Rynd Smith and the East Anglia One North and Two Case Team Our ref: PL00088303 & PL00541702

Your ref: EN010077 & EN010078

Planning Act 2008, Scottish Power Renewables, Proposed East Anglia One North (EA1N) and Two (EA2) Offshore Windfarms

Historic England Deadline 6 Response

**Viewpoint 5 Public Rights of Way, near  
Moor Farm (with National Grid GIS  
Substation)**

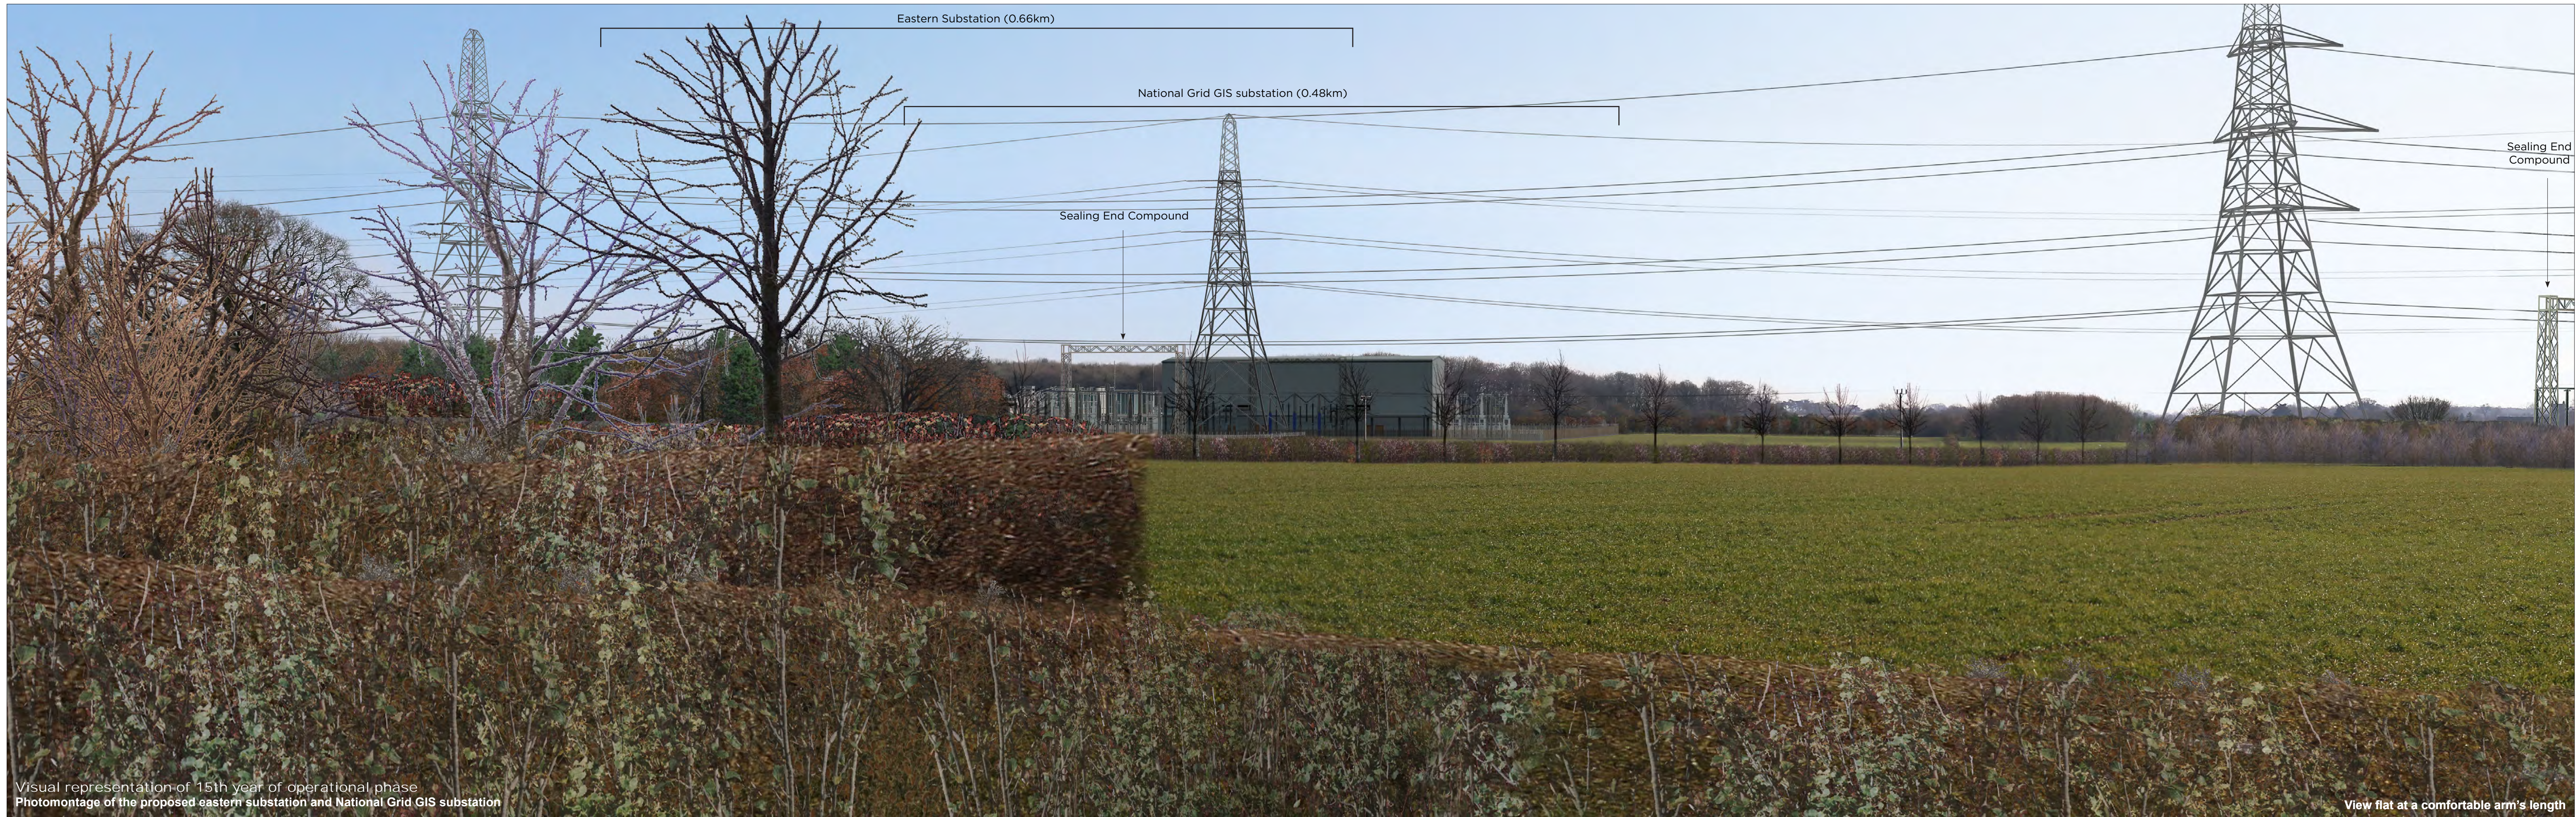
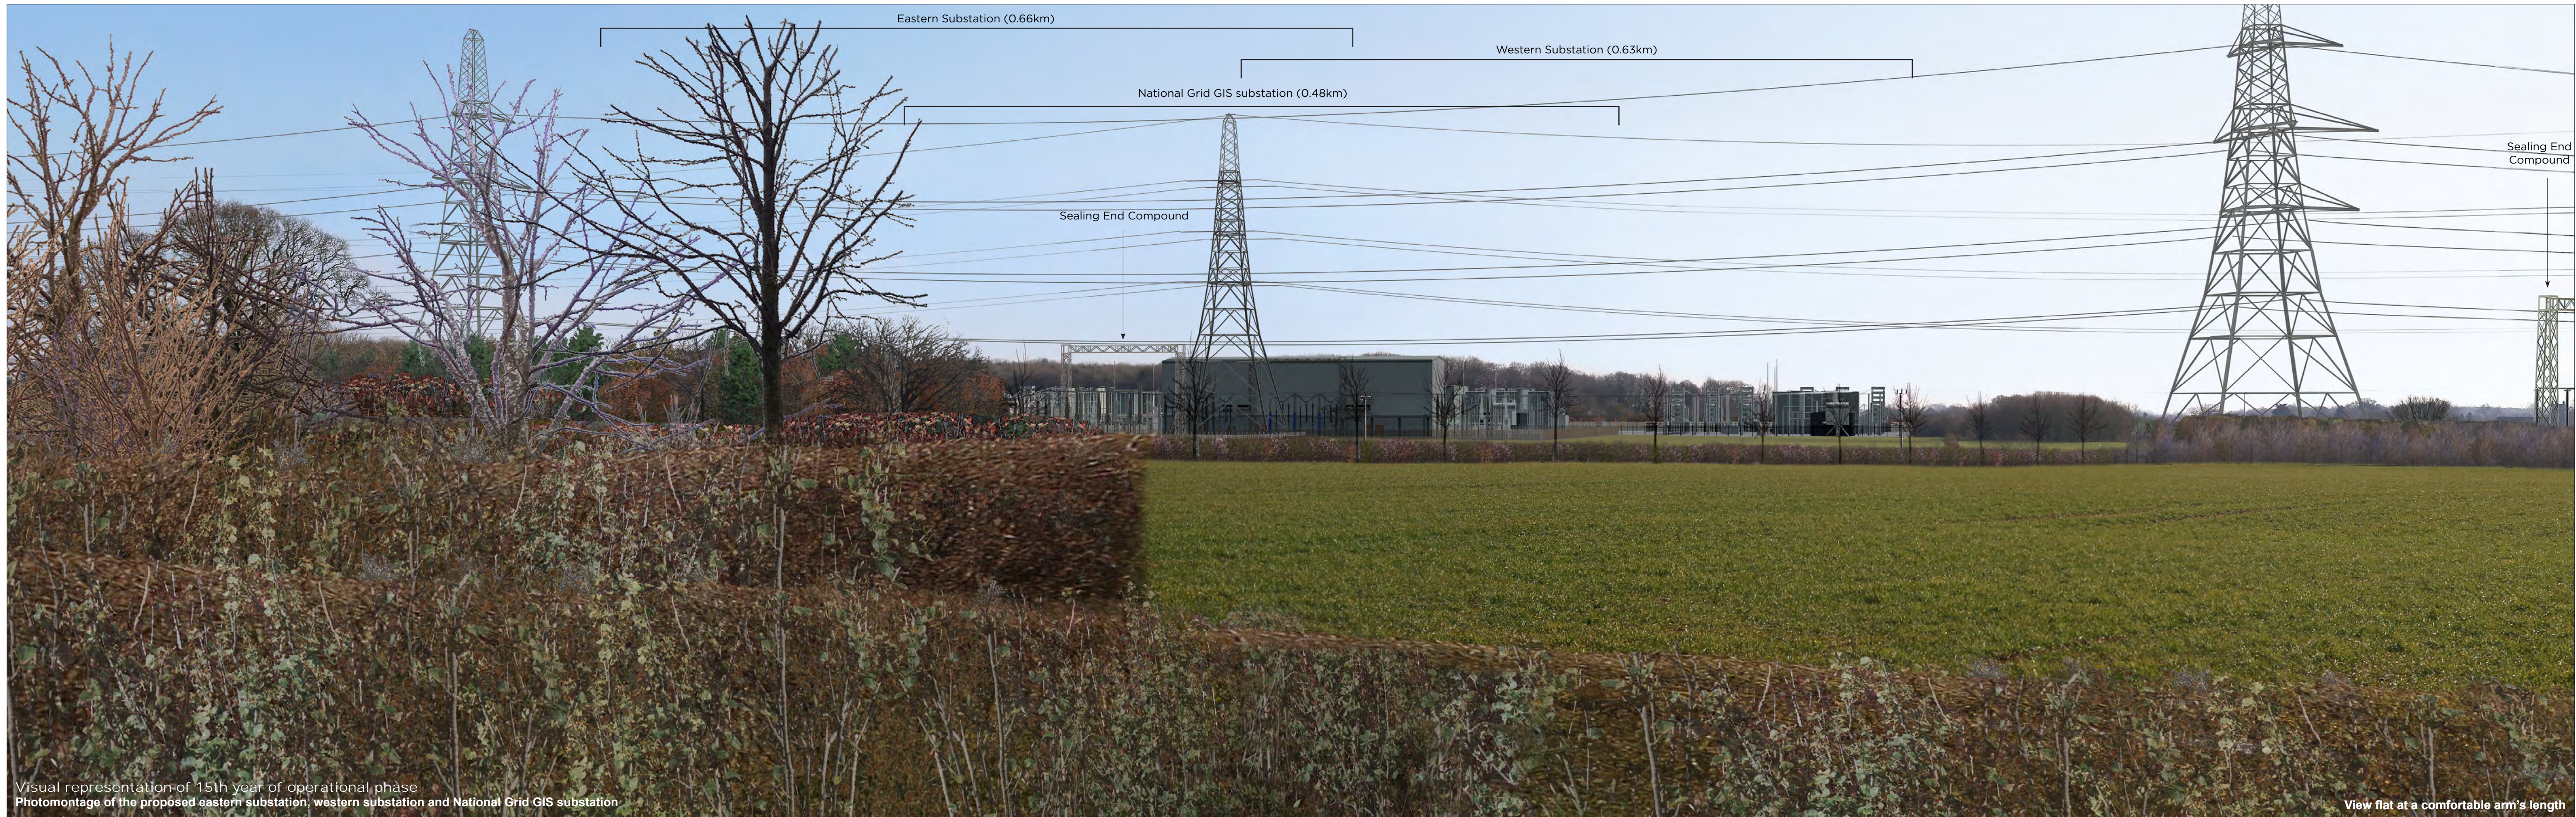
This is particularly apparent in those key views of the Church from Moor Farm, where the development would cut across the footpath which runs from Friston to Moor Farm to the north of the church. The use of planting to here to screen the development would have the effect of screening out the substation in the immediate foreground but, because it would continue to block and restrict the key views of the church and remove those views it remains harmful.
